**WELWYN HATFIELD BOROUGH COUNCIL
ASSISTANT DIRECTOR (PLANNING)**

DELEGATED APPLICATION

Application No: 6/2023/1934/HOUSE
Location: 9 South Drive Cuffley Potters Bar EN6 4HP
Proposal: Retention of two dormers and erection of two dormers on each side facing roofslope
Officer: Ms Kirsty Shirley
Recommendation: Refused

TITLE:  
Right Elevations

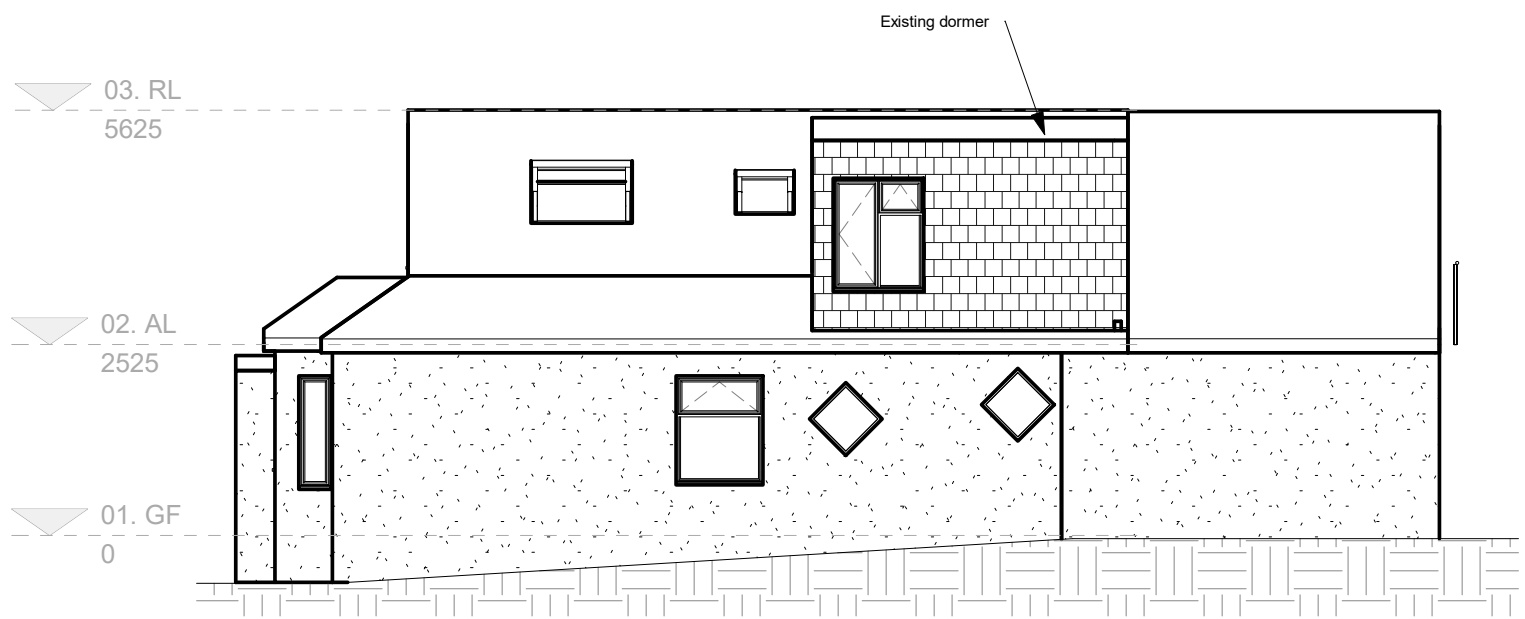
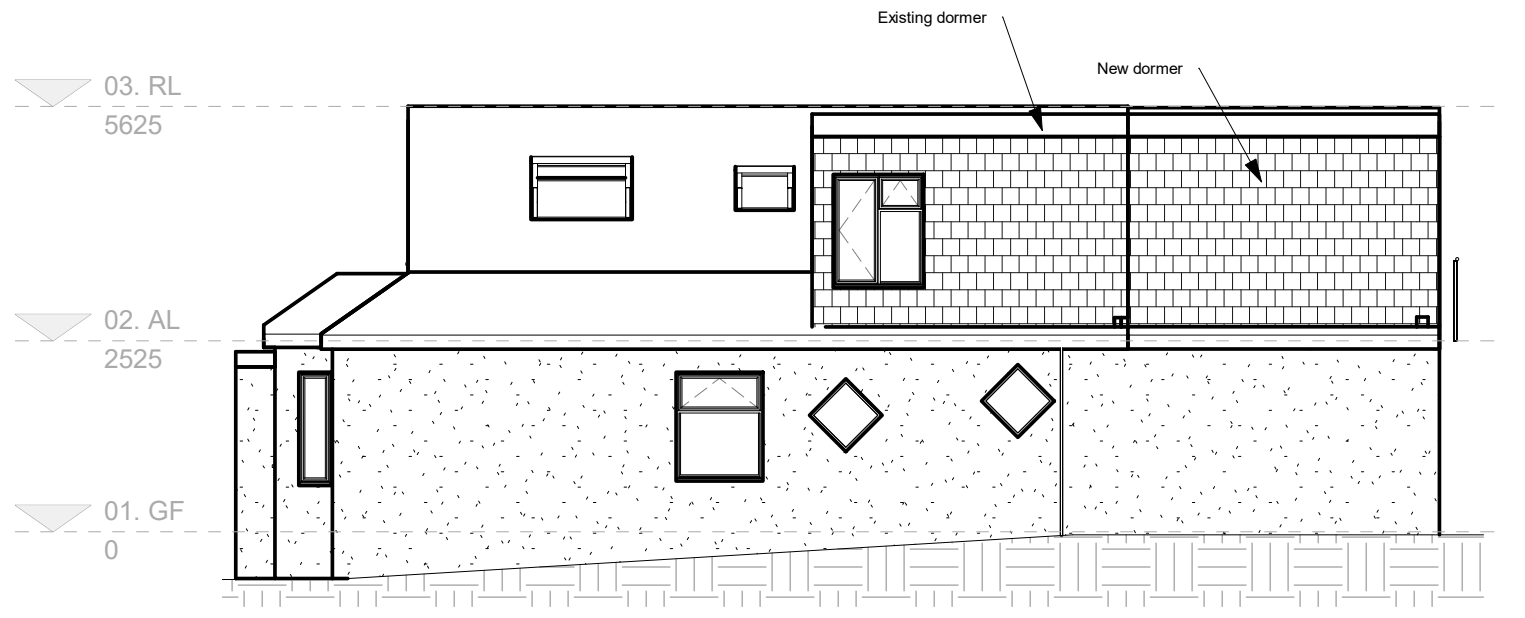
The proposed development is considered to be for the retention of two dormers. The dormers are positioned to either side of the flank roof slopes. The scale and design of the fenestration within the dormers is out of keeping with the existing fenestration within the flank elevations of the dwelling. While the dormers do not exceed the ridge of the dwelling, the dormers are set very minimally below the ridge of the dwelling, and the rear facing dormer cheeks finish in line with the rear elevation of the dwelling. The dormers are substantial in size and scale and occupy the majority of their respective roof slope, which is further emphasised by the positioning of the dormers within the roof slope.

<p>size that would have an unduly overbearing or undue dominance towards adjoining neighbours.</p> <p>The dormer facing towards No. 7 have three windows and the dormer facing towards No. 11 has one window within the respective flank elevations.</p> <p>The windows facing No. 7 serve two non-habitable spaces and a bedroom. The windows serving the non-habitable spaces could be secured by condition to be obscured glazed in the event of an approval to maintain the privacy of the occupiers of No. 7. The bedroom would also be served by Juliet balconies within the rear elevation and so the flank window serving the bedroom could be obscured glazed as the Juliet balcony would allow sufficient light and good quality internal living space, while maintaining the privacy of the occupiers of No. 7.</p> <p>The window within the dormer facing towards No. 11 serves a bedroom. No. 11 has rooflights within the roofslope facing towards the application dwelling. The dormer window would allow direct views into No. 11's rooflights due to the positioning of the window within the dormer and orientation and positioning of the rooflights. However, no other windows serve the bedroom, and an obscured glazed window would result in poor internal accommodation for future occupiers.</p> <p>The dormer facing towards No. 11 would therefore result in an unacceptable loss of privacy to the occupiers of No. 11 as a result of overlooking towards the rooflights within the north facing roofslope of No.11. The dormer is therefore contrary to Local Plan Policy SADM11; the Council's Supplementary Design Guidance; and the National Planning Policy Framework.</p>
